**Portland Fire Department**

RE: 59 STATE ST  
PORTLAND, ME

**NOTICE OF VIOLATION  
AND ORDER TO CORRECT**

Existing Apartment Building
59 STATE STREET
PORTLAND, MAINE
PARTIAL TYPICAL FLOOR PLAN

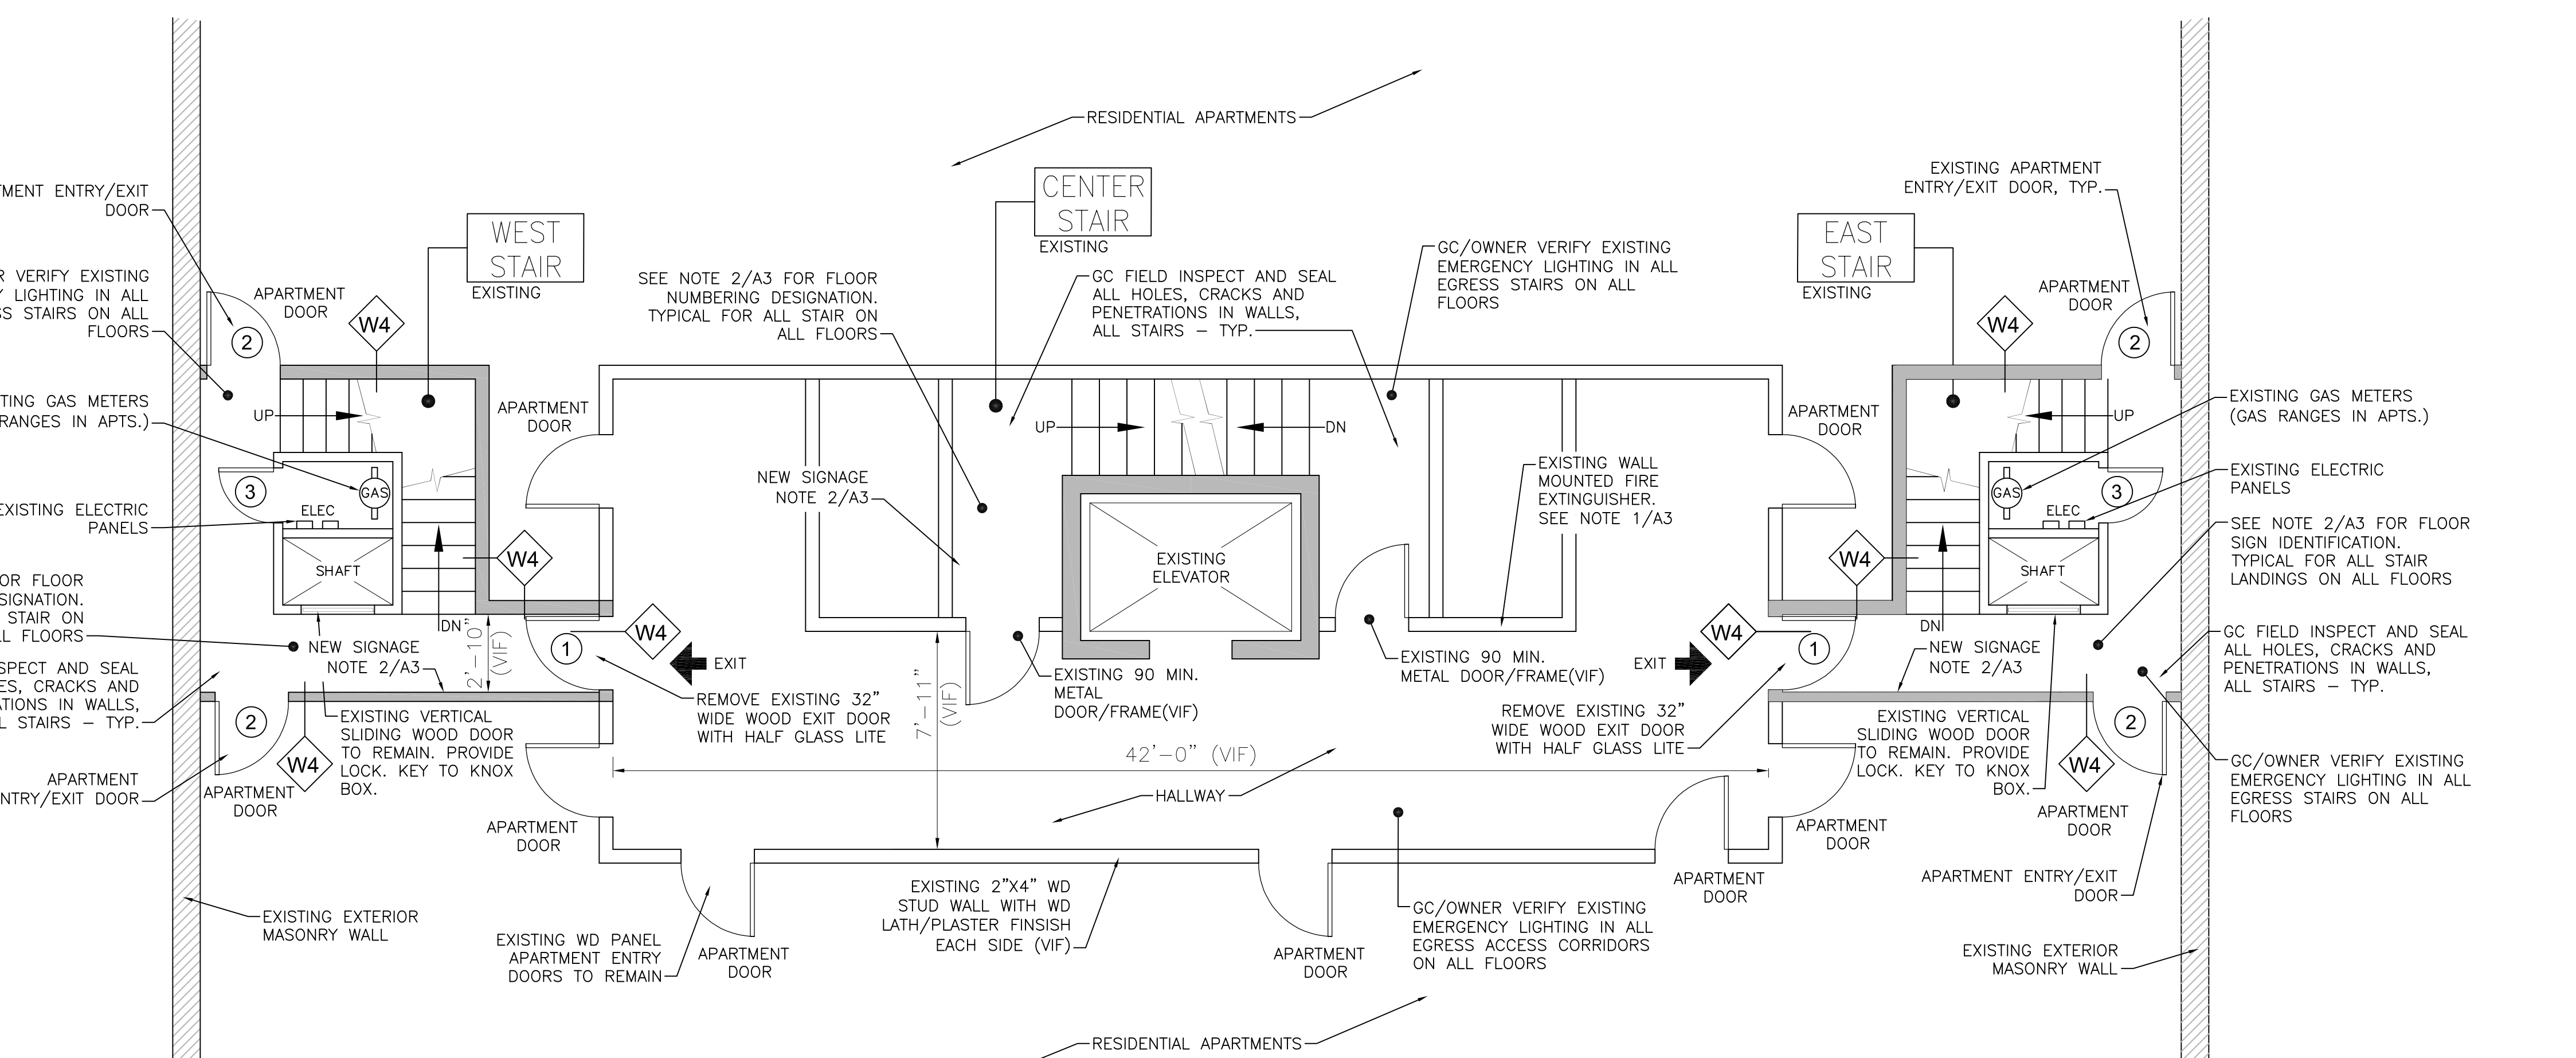
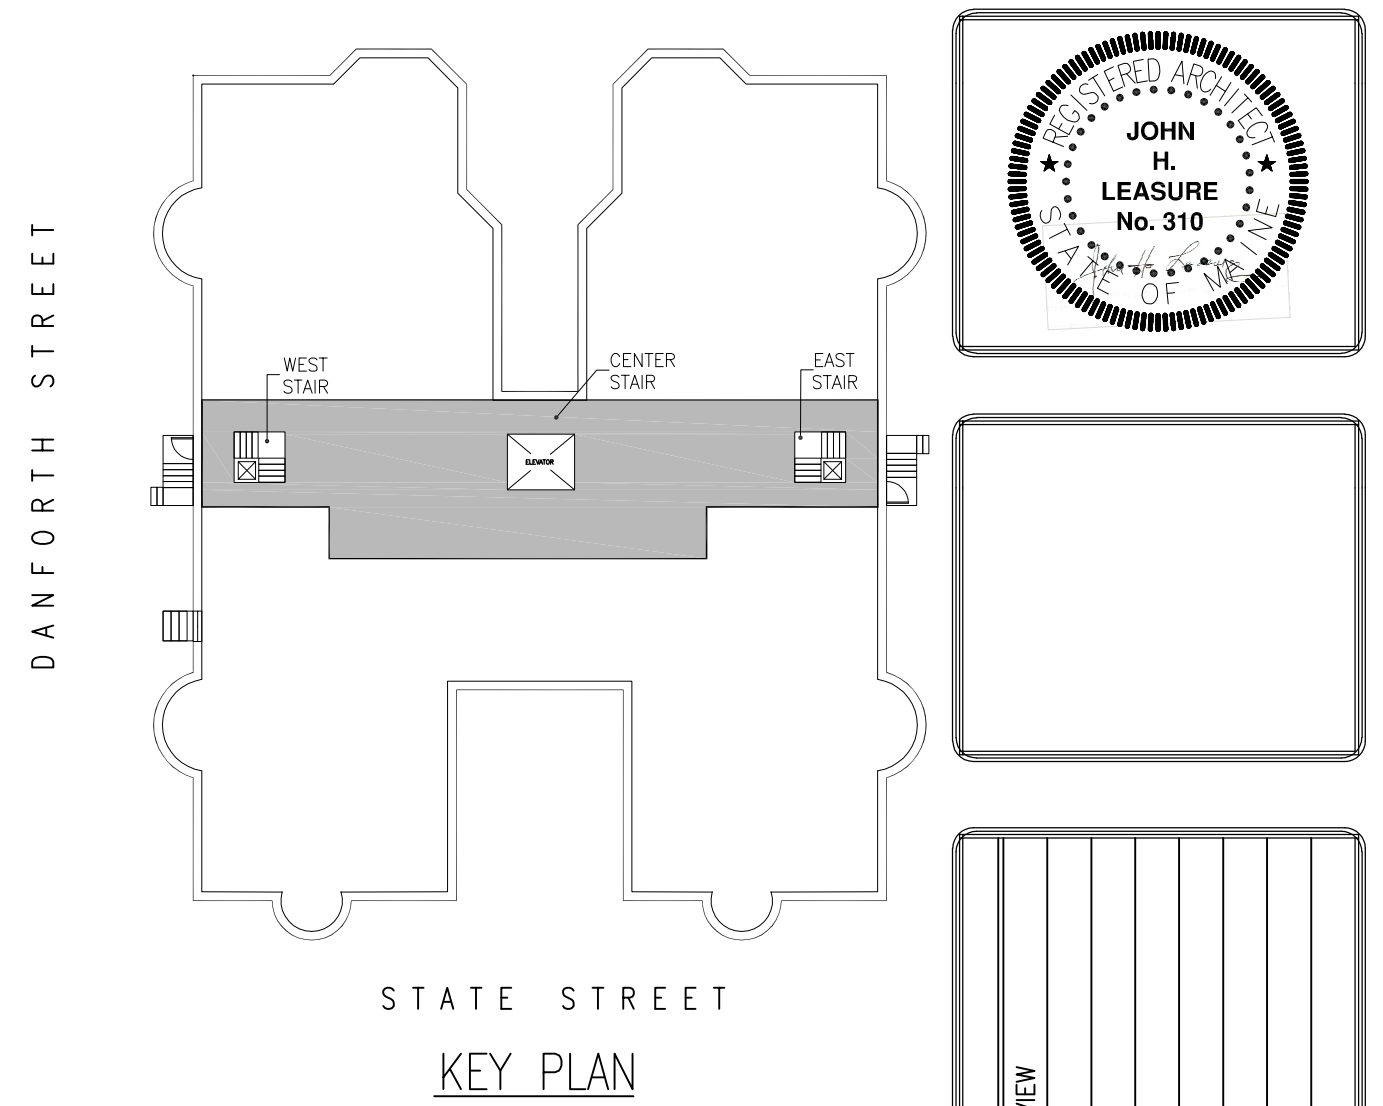
<b>NAME</b>	<b>CODE DESCRIPTION</b>	<b>COMMENTS</b>	<b>Deadline</b>
NFPA 101-31.2.2.1	1-hour fire rated doors and assemblies required, including self-closing and self-latching mechanisms.	Egress stairwells at either side of building aren't protected by fire doors, wooden doors with half light glass/plexiglass on all floors require replacement.	10/19/2018
